# CITY OF ALBUQUERQUE

March 1, 2016

**Re: Independence Square  
Erosion Sediment Control Plan  
Engineer's Stamp Date 2-5-16 (E17E076)**

Erosion Sediment Control Plan

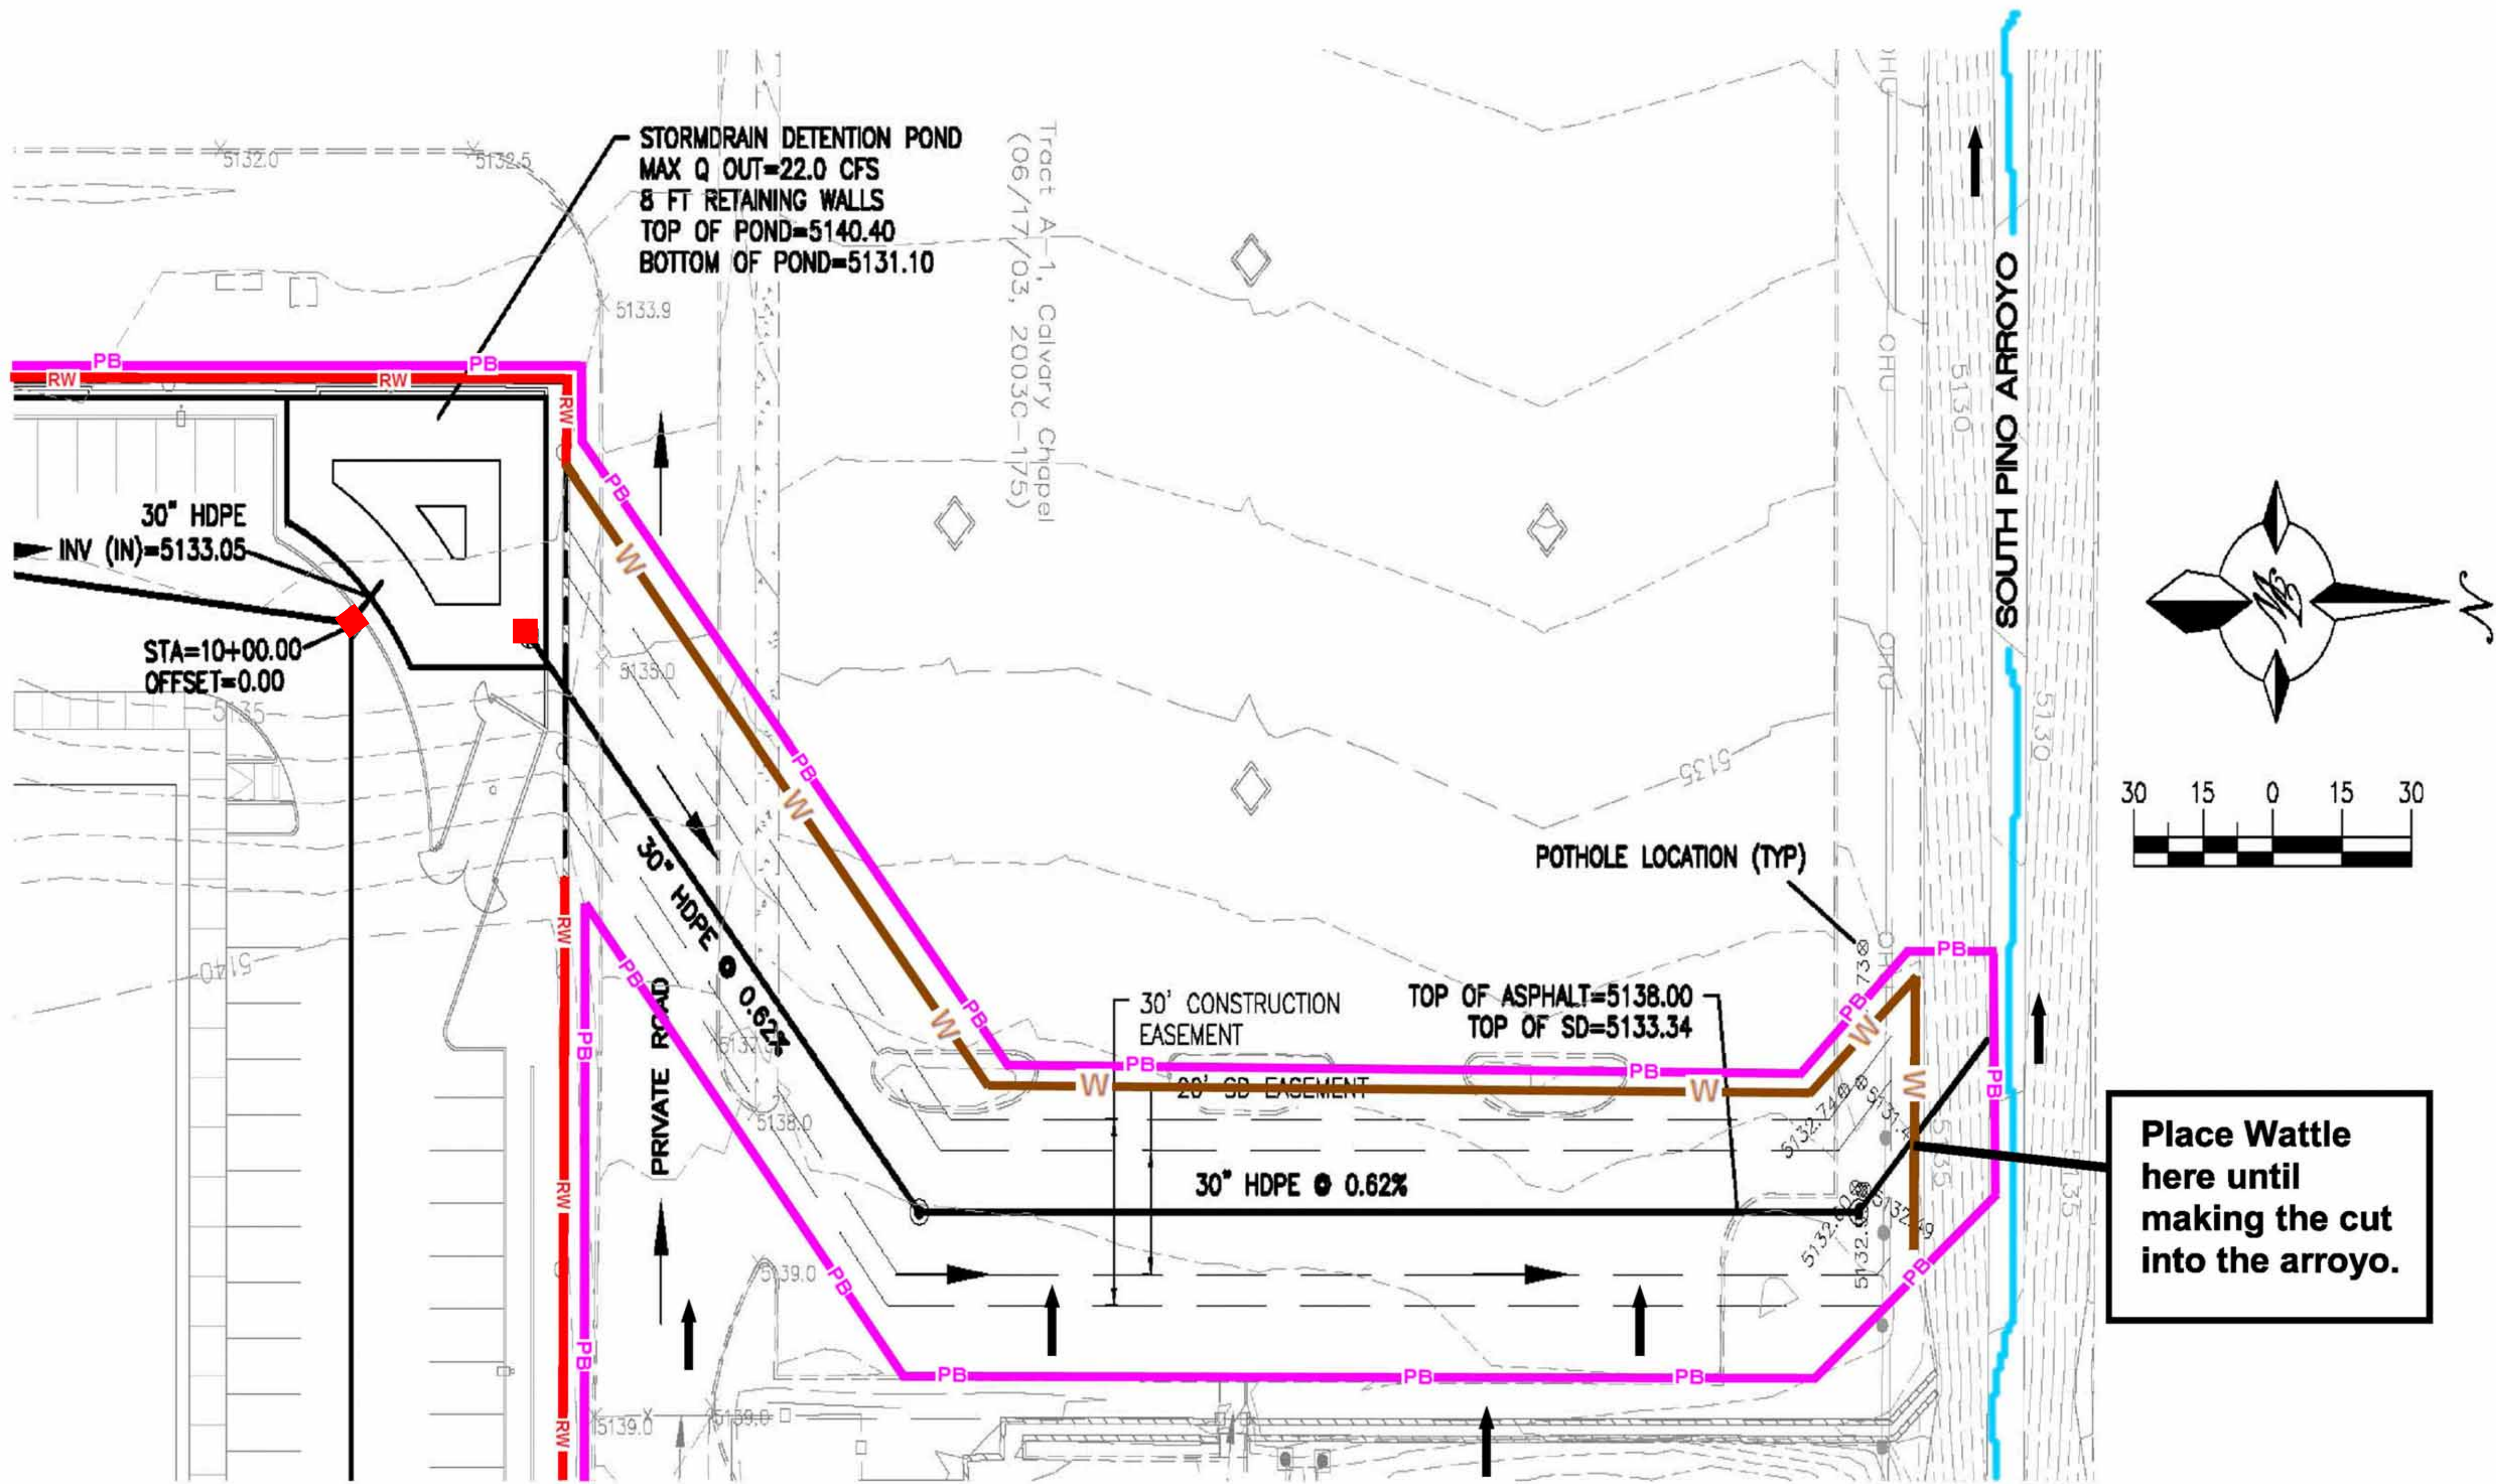
1. The plan does not show the storm drain to the Pino Arroyo and the associated BMPs.
2. Storm inlets are shown, but inlet protection is not specified.
3. A "Curb Storm Drain Inlet Filter" is shown, but the inlets appear to be "at grade" not in a curb.
